Subject: Planning Application 2025/44/92737/E and 2025/61/92713/E Objection

I note that we now have the following Consultation Response from: KC Environmental Health (Pollution & Noise Control) 2025/92737 - rear of, 23 to 43, Moor Lane, Gomersal, Cleckheaton, BD19 4LF

Reference is made to the discharge of reserved matters one of which being no.24 (acoustic barrier). They have commented as follows:-

Project	Proposed residential development at land off Moor Lane, Gomersal
Client	Binks Executive Homes, Blakeridge Mills, Batley
Dwg Title	(21942)10_Access Road Elevations
Scale	1: 100 @ A2
Date	July 23

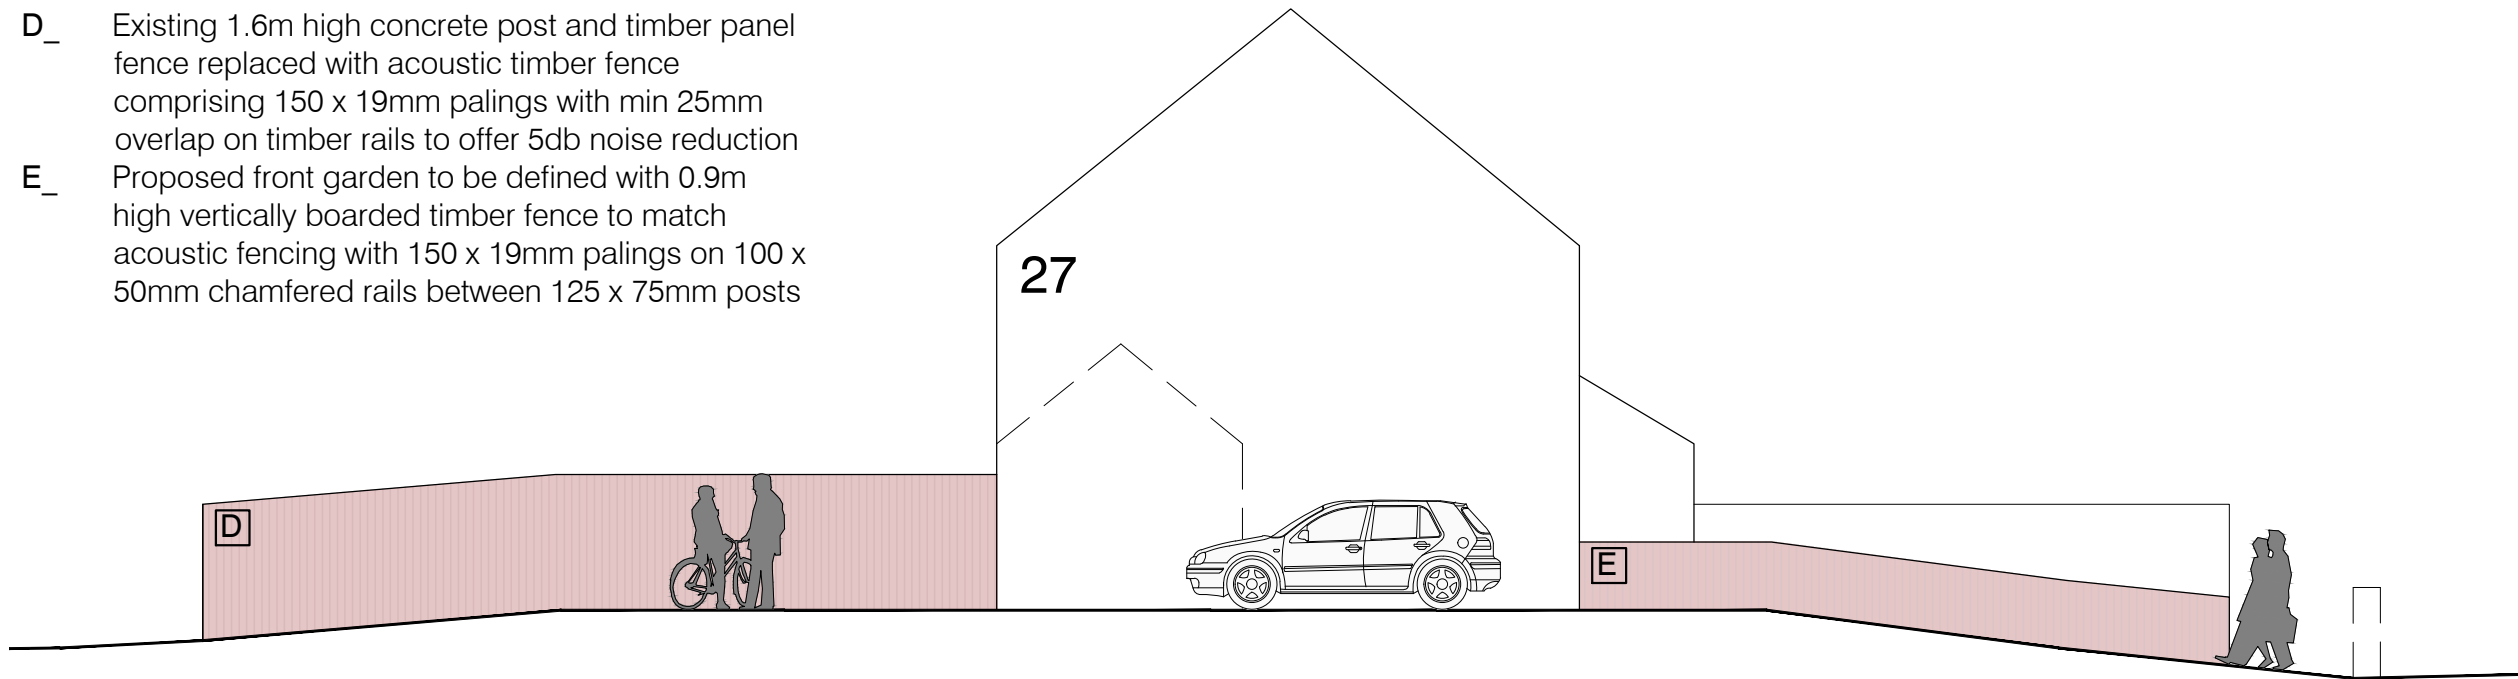
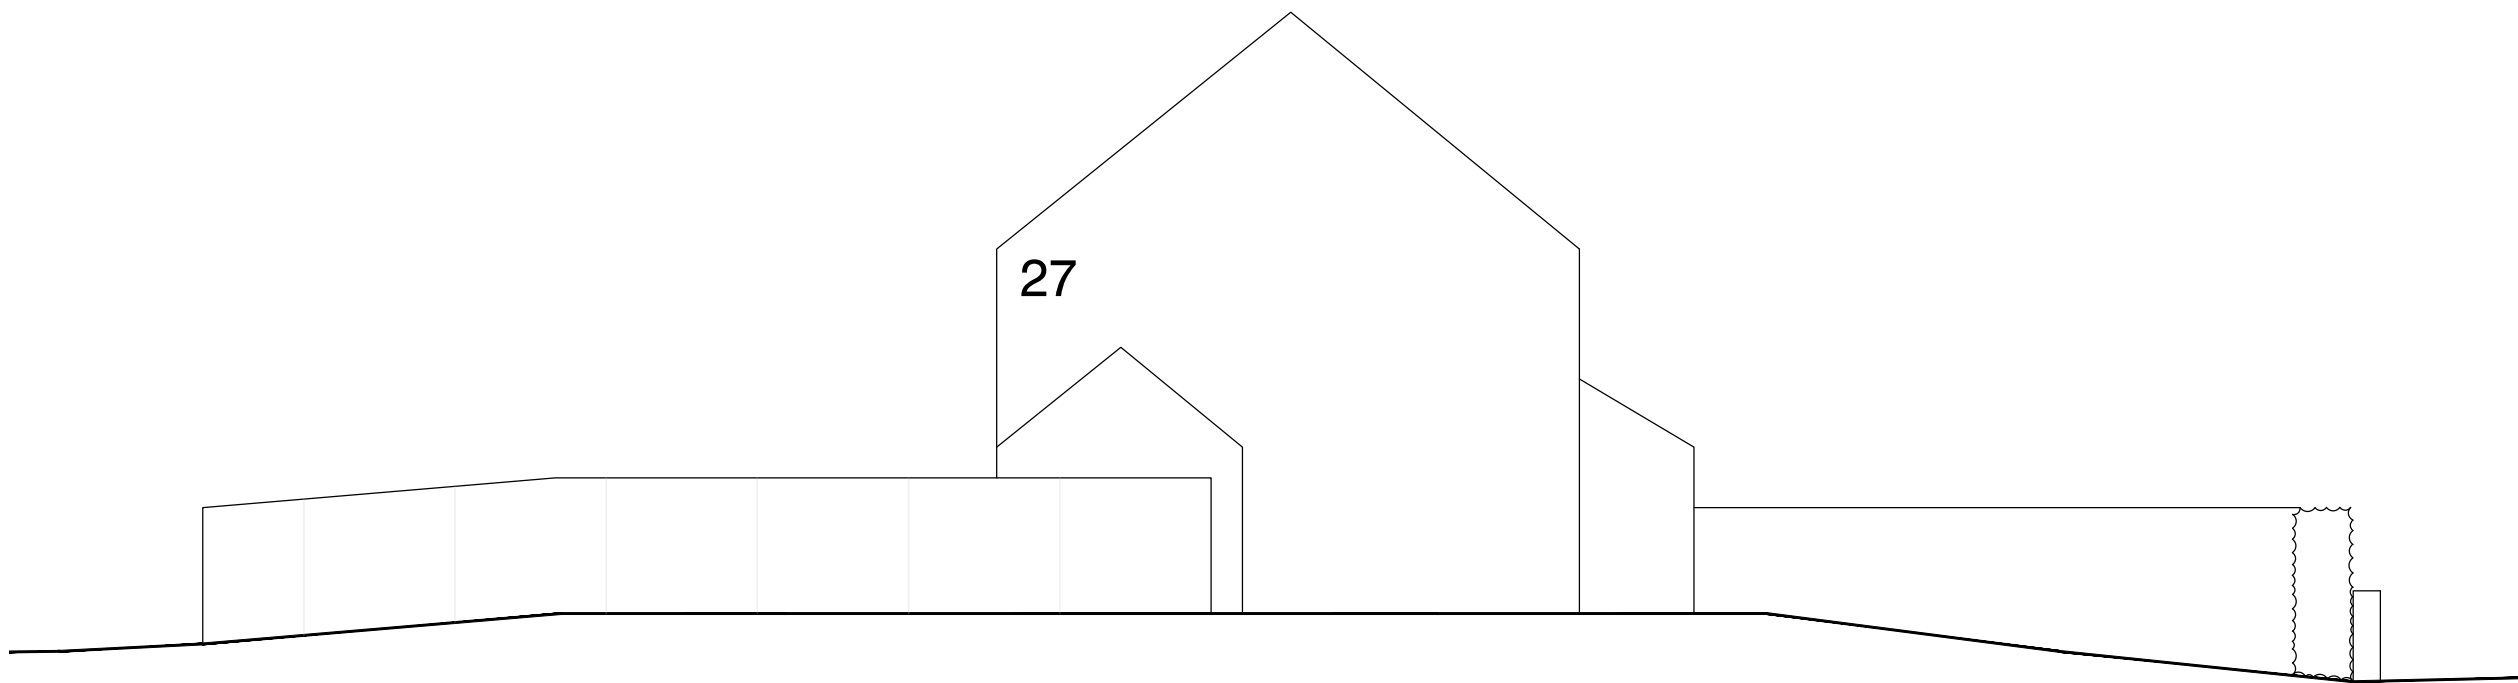
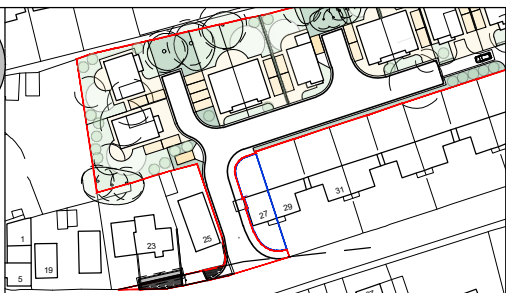
“Based on the information presented in the submitted drawing Ref: 21942-10 Access Road Elevations, dated July 2023, the proposed acoustic barrier could only achieve noise reductions at ground floor level. Noise from road traffic accessing the site will not be reduced by the installation of a noise barrier at first floor (bedroom window height). Noise reductions at first floor level could only be achieved by installing acoustic glazing – as can be seen in the drawing Ref: 21942-10, Access Road Elevations, dated July 2023”.

What I did find incredulous at the time was the specification for the acoustic screen. This was to replace the existing Waney Lap timber fence with an acoustic timber fence, comprising 15mm x 19mm pailings with a minimum 25mm overlap on timber rails, to offer a **5 decibel noise reduction**. This was below the window cills on the ground floor of 25 Moor Lane, which is of brick and block construction, but no thought was given to providing any form of additional sound insulation to the 3 windows directly above.

To put this into context, and in simple terms, a 5 decibel noise reduction would only reduce the sound level of a Diesel Truck passing the property from **84 dB to 79 dB**.

My research shows that to provide any significant sound reduction this can only be made with a specialised acoustic fence installation which would then achieve a reduction of 20 to 32 dB under optimal conditions. Also, as pointed out by K C officers, acoustic glazing would need to be addressed.
